From: [REDACTED]
Sent: 22 August 2025 10:37
To: 'Andrew Rockett'
Subject: Wroxton second draft

We write in relation to the works undertaken to stabilise the independent barn adjacent to the North Arms, Wroxton, with particular focus on the two comments from Cherwell District Council;

Drawing Title  
**Outbuilding / Garage General Arrangement**

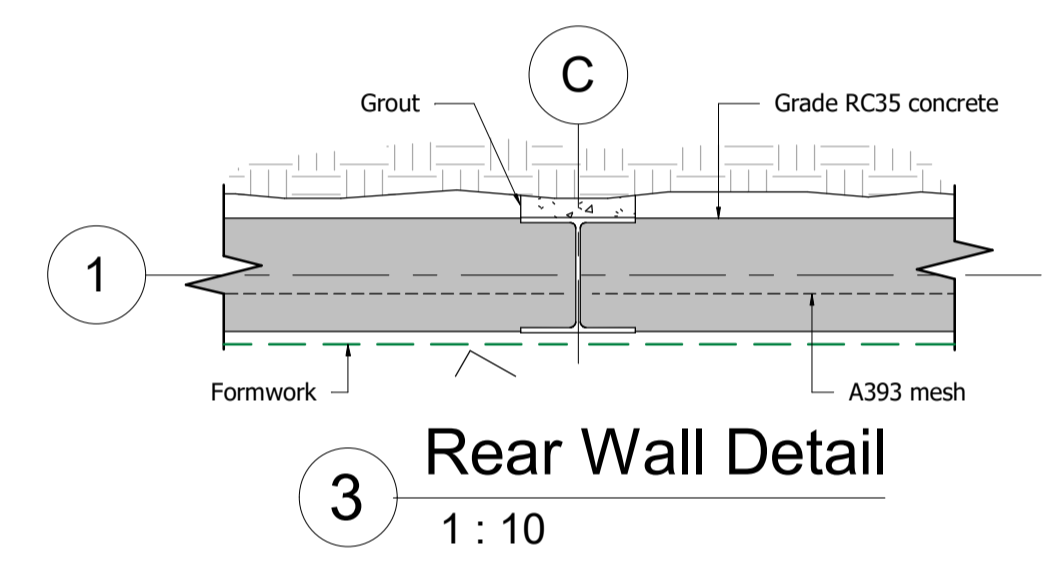
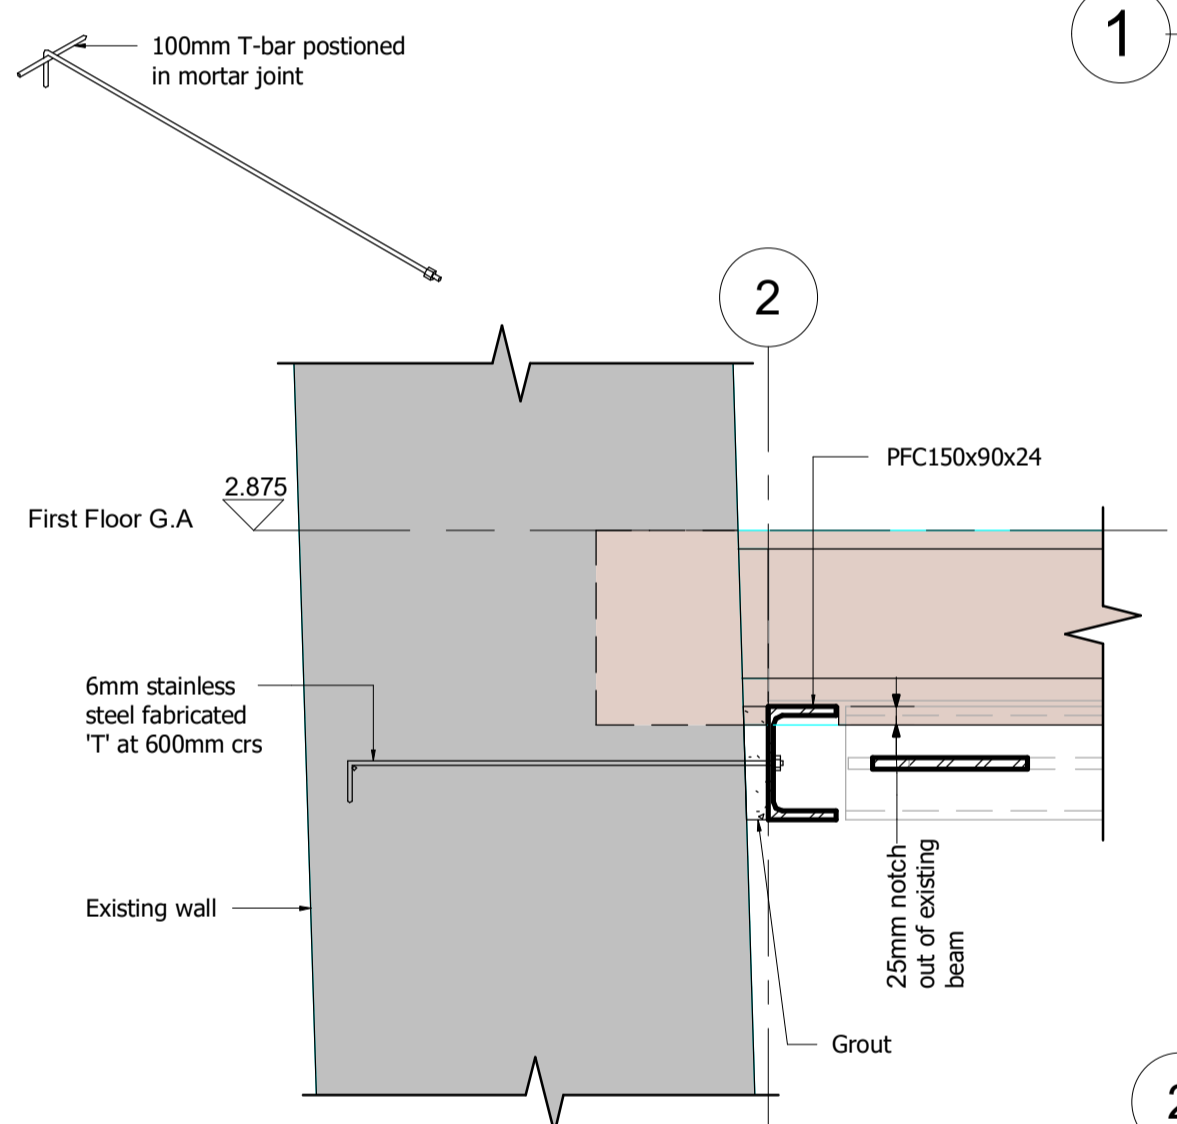
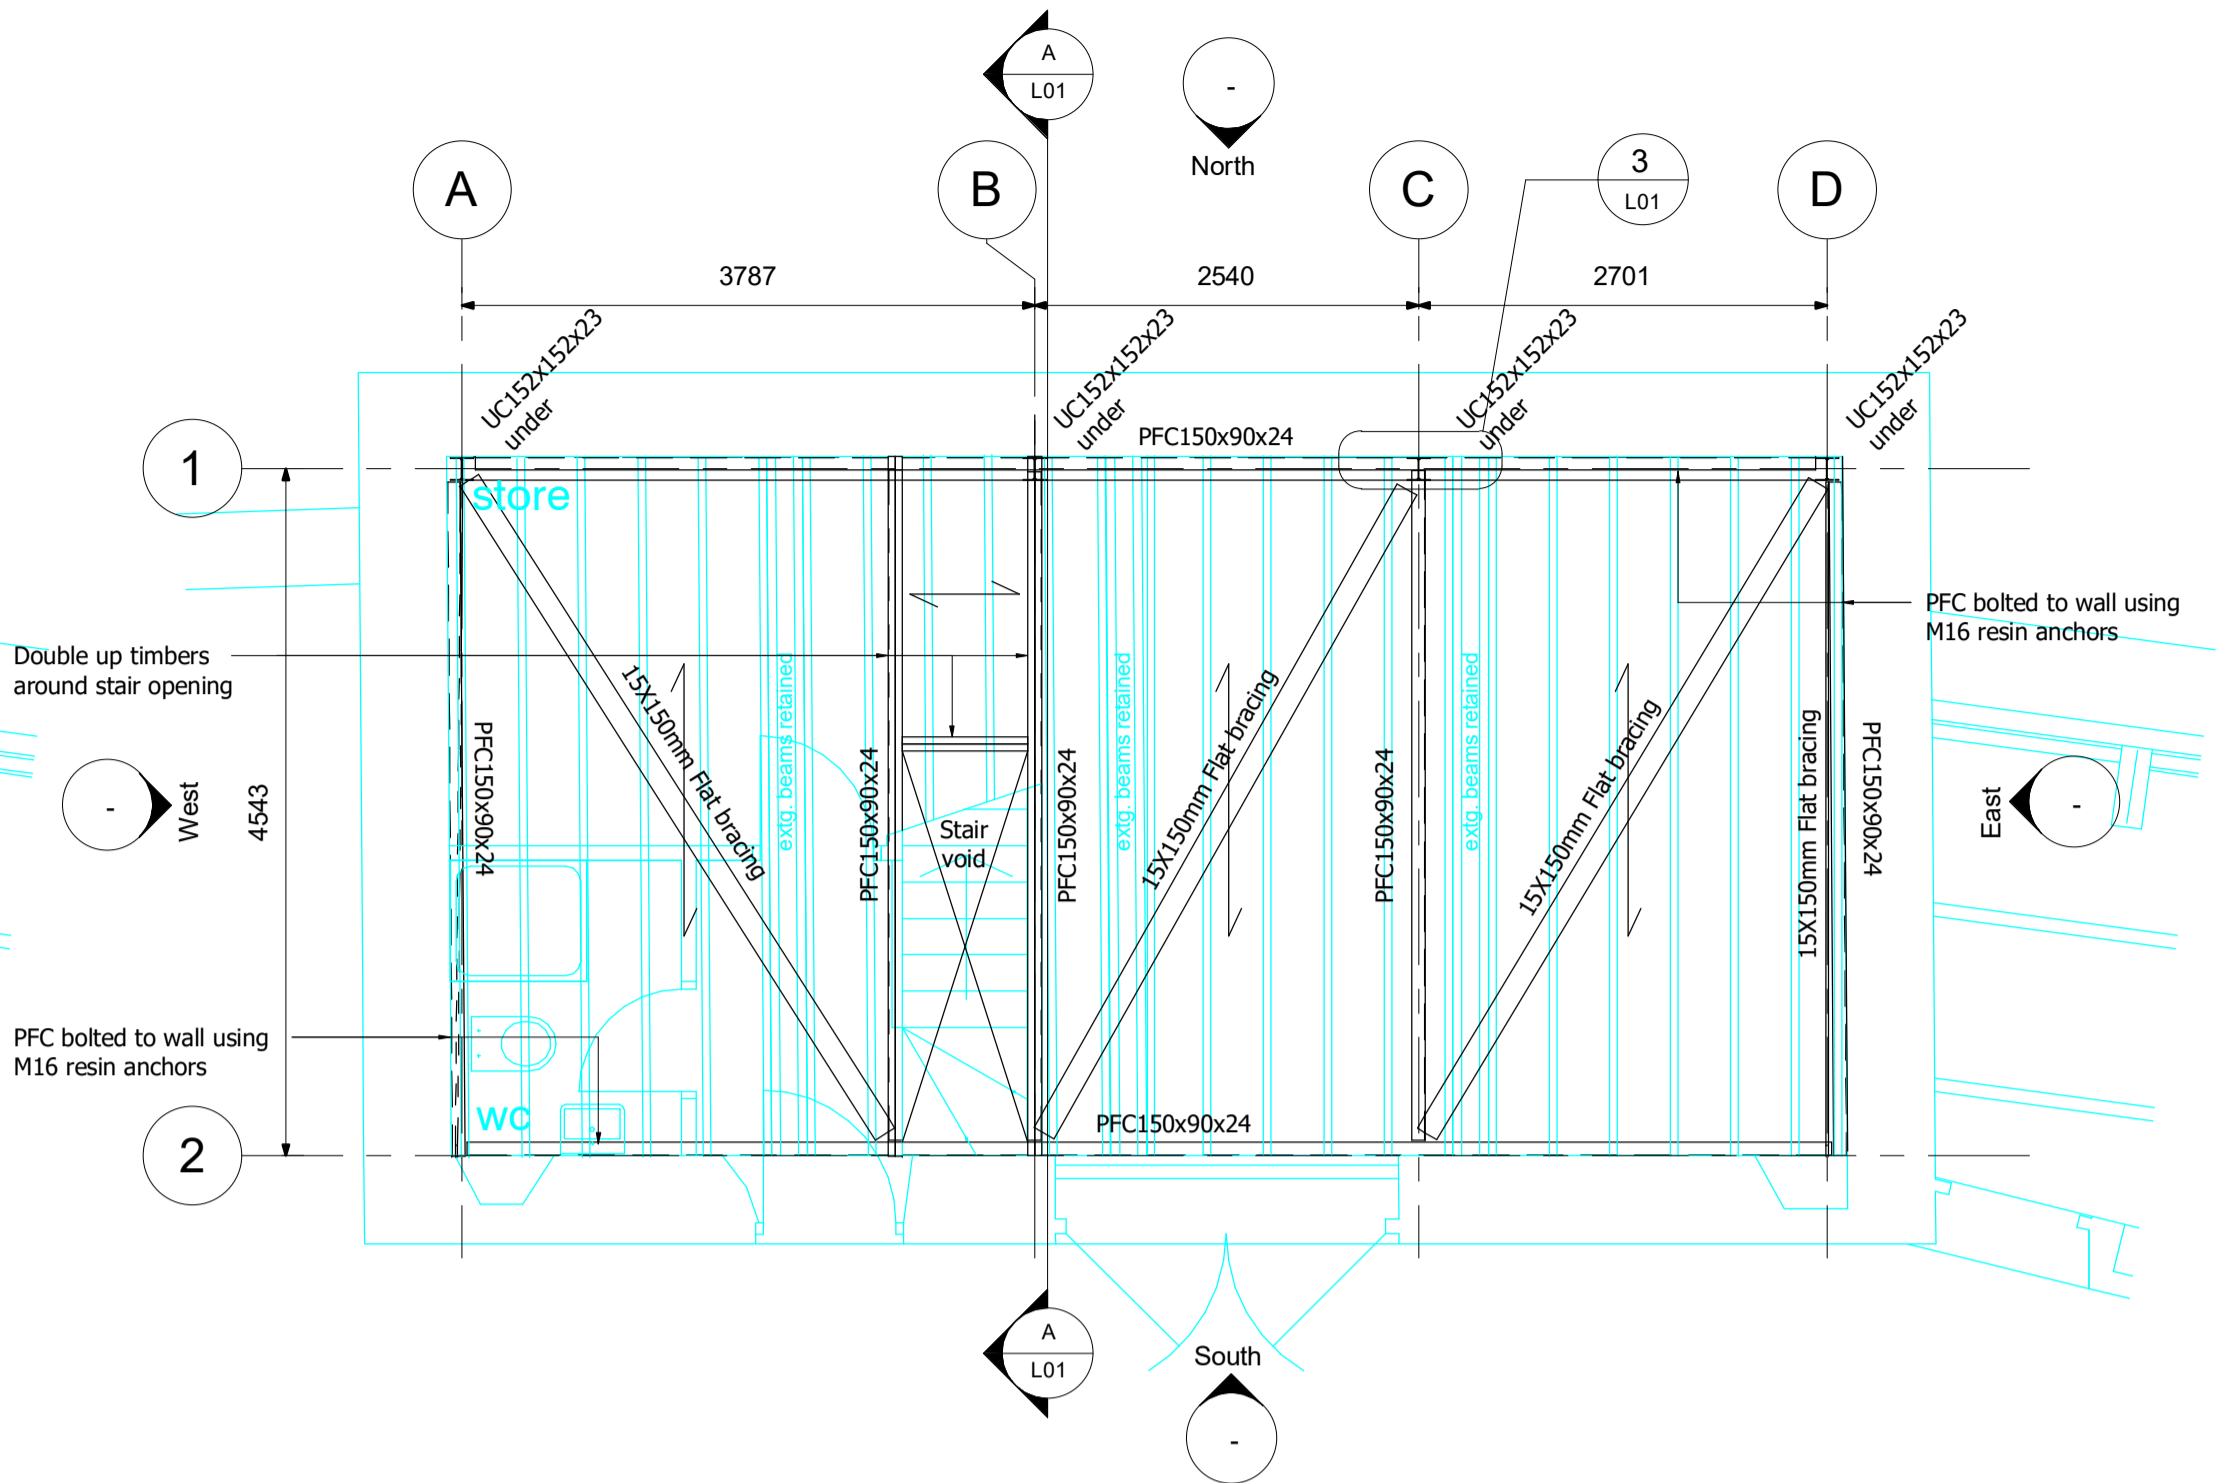
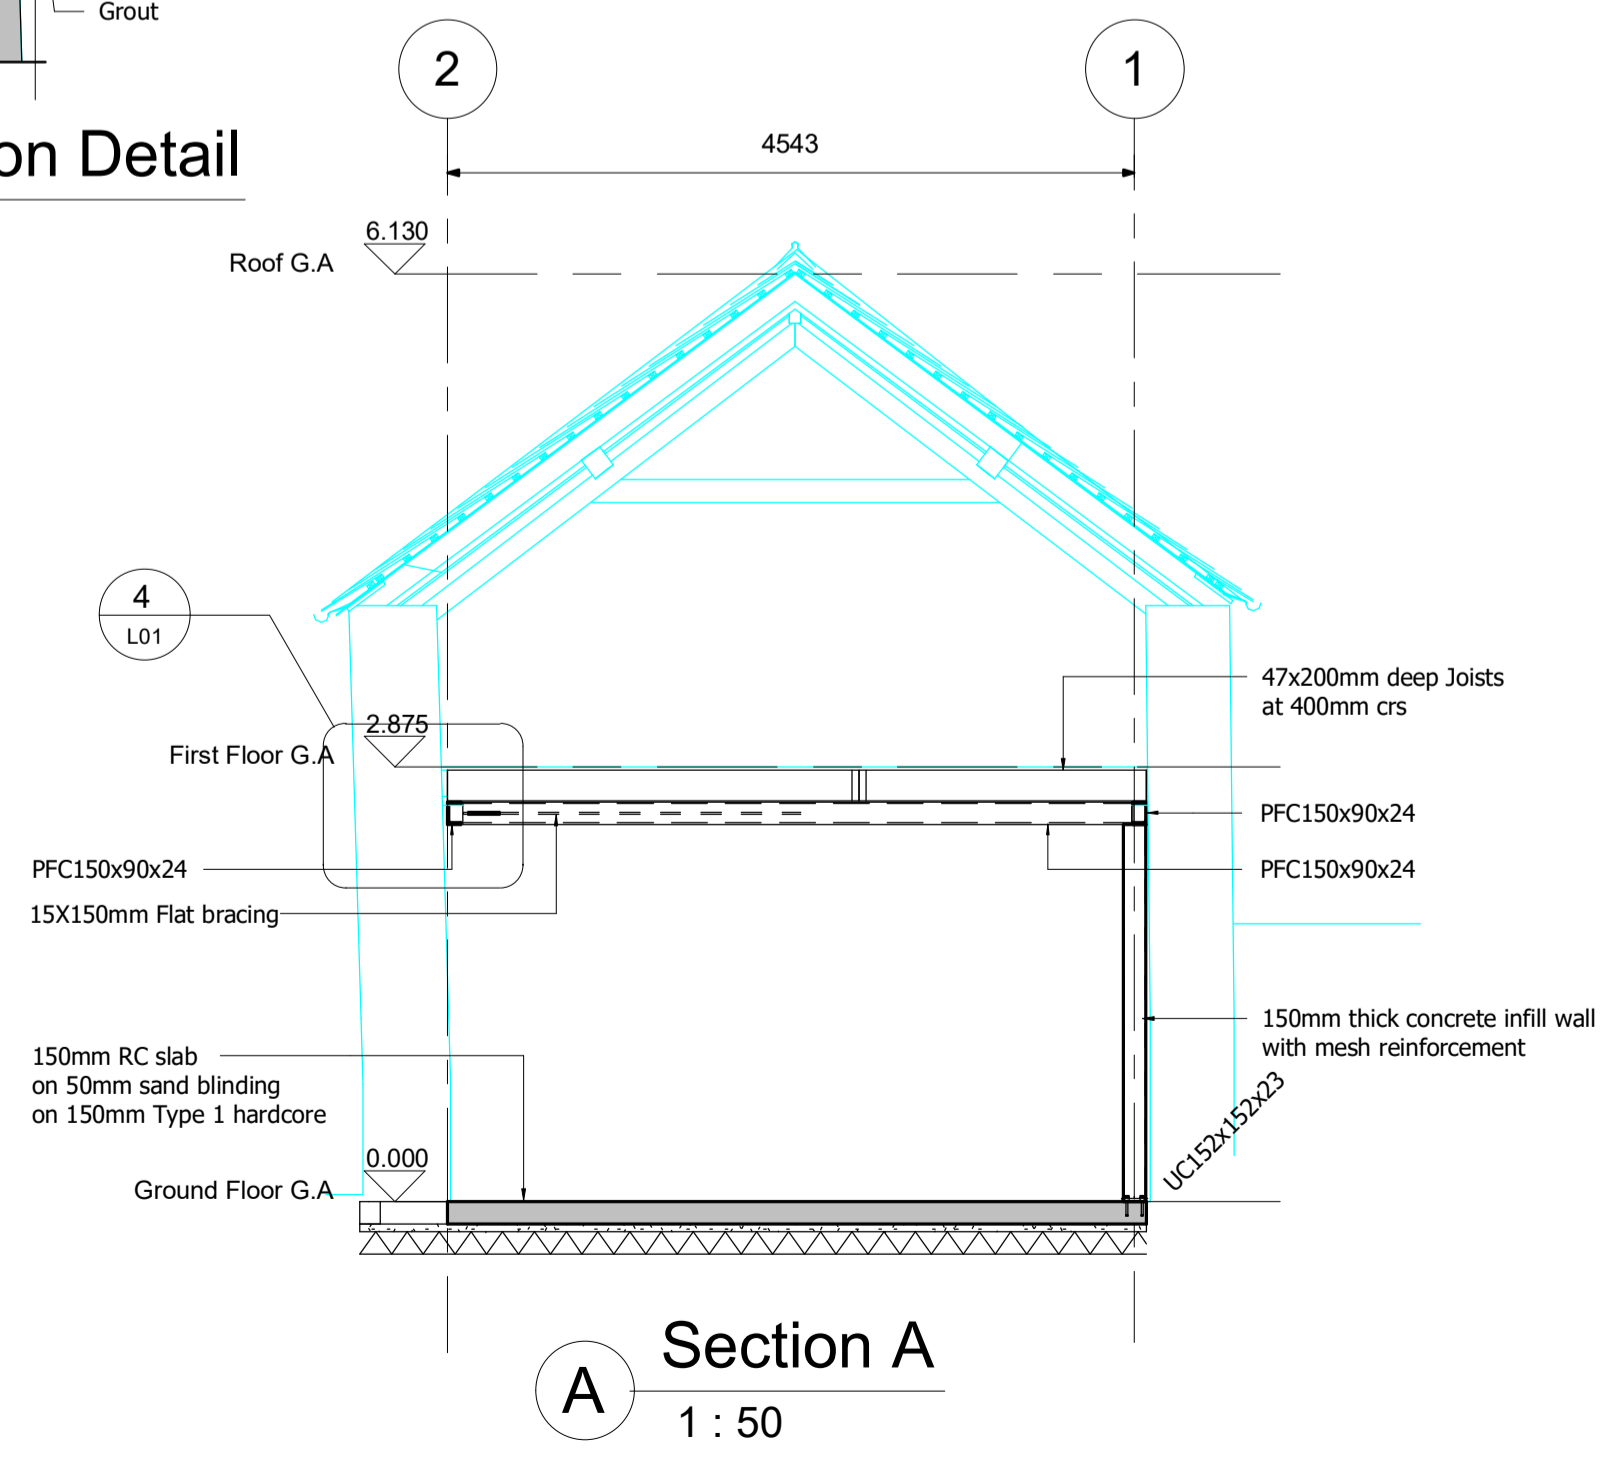
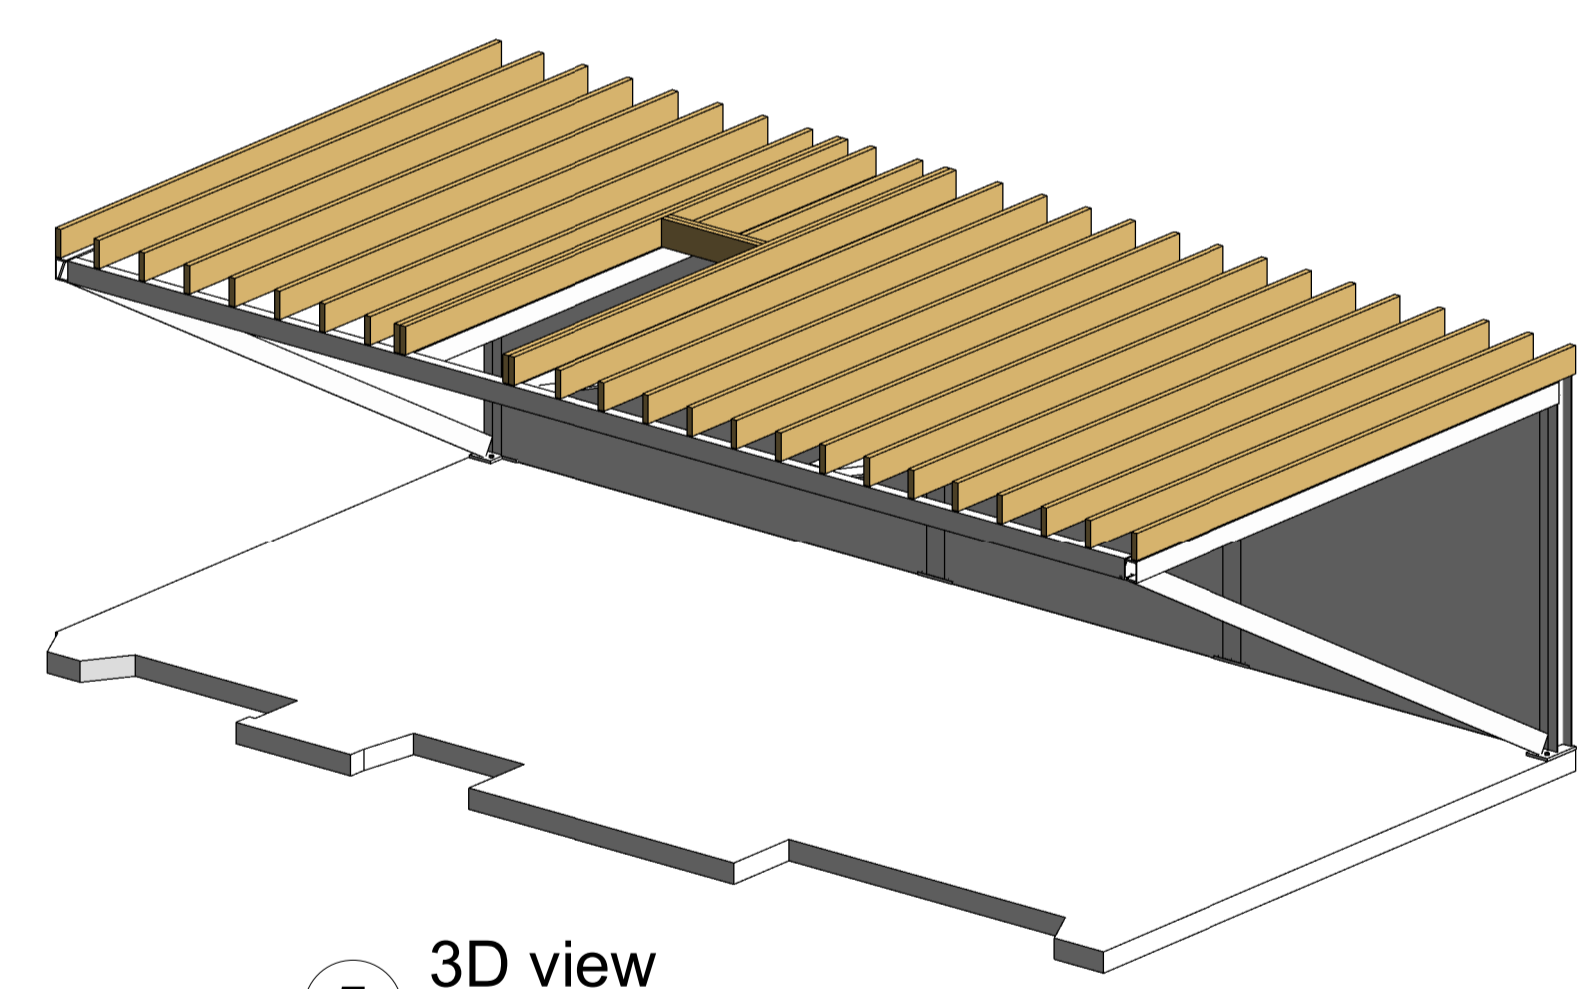
Clarification is needed on the works undertaken; what work has been done, how is internal wall attached ; full methodology and justification

Justification should be provided for cutting of the existing beam to install steel framing ; justification and specification of steel frame is needed

In order to retain as much of the original historic walls as possible it was decided to cast a new concrete support wall in front of the original stone wall and to leave the stone wall in place. It was necessary for the concrete wall to provide lateral overturning resistance and if this were to be achieved with a concrete base in a traditional “L” shaped wall, extensive excavation would have been necessary at the base of the wall, which in itself would have been destabilising. It was therefore proposed to erect a steel grillage frame which would be

braced back to the side walls rather like a series of buttresses to allow the concrete to be cast in panels, which were then themselves supported by the frame. This work only involved localised excavation next to the base of the wall to form footings for the steel posts.
